CITY OF ALBUQUERQUE

June 10, 2014

**RE: Pasadena Office/Warehouse
Grading and Drainage Plan
Engineer's Stamp Date 6-3-2014 (B18D019)**

Date:	No.	Revision:	Date:	Job No.
5/8/14				2052
Drawn By: BJB				CG-101
Ckd By: FCA				SH. OF

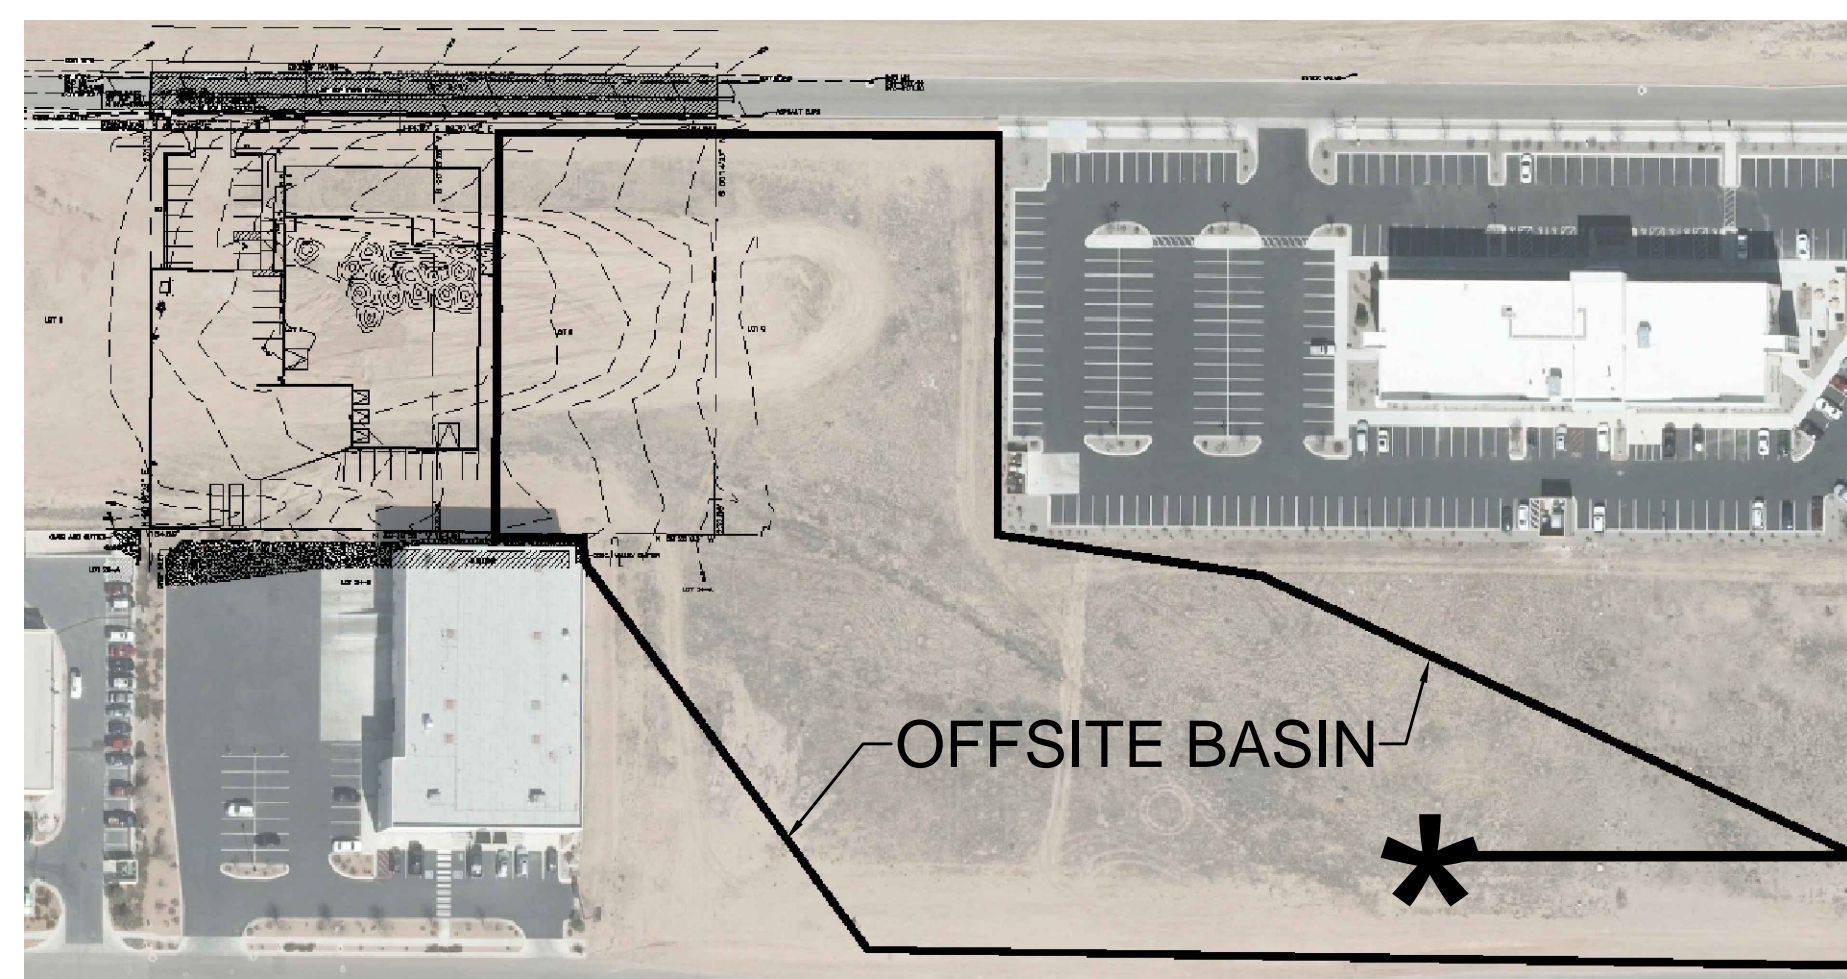
1. The As-Builts of the existing Storm Drain (CPN # 630982) show a 36" Storm Drain in front of Lot 5A, and the report in Weiss Engineering (Drainage File B18D006) indicates that 36" Storm Drains were intended for this street, and both indicate 60 cfs

2. Construction drawings (CPN# 546991 – in B18D006) show 48" SD pipe in San Mateo connection to SD pipe in Pasadena with an HGL close to surface. The same is shown in As-Builts (CPN#630981) Sht 10/15. Therefore, downstream pipe cannot accommodate additional flows for which it was designed.

3. In Drainage Report for Citicorp Site by Bohannon-Huston (1996) developed conditions for this area are limited to 4.1 cfs/acre whereas this Plan shows 4.7 cfs/acre. Flows should be reduced to the design flows.

4. The offsite basin does not account for flows west of I-25 and south of development on Lot 10A.
5. Submit calculations showing Storm Drain upstream of the 36" pipe in Pasadena can be downsized per Work Order plan set.
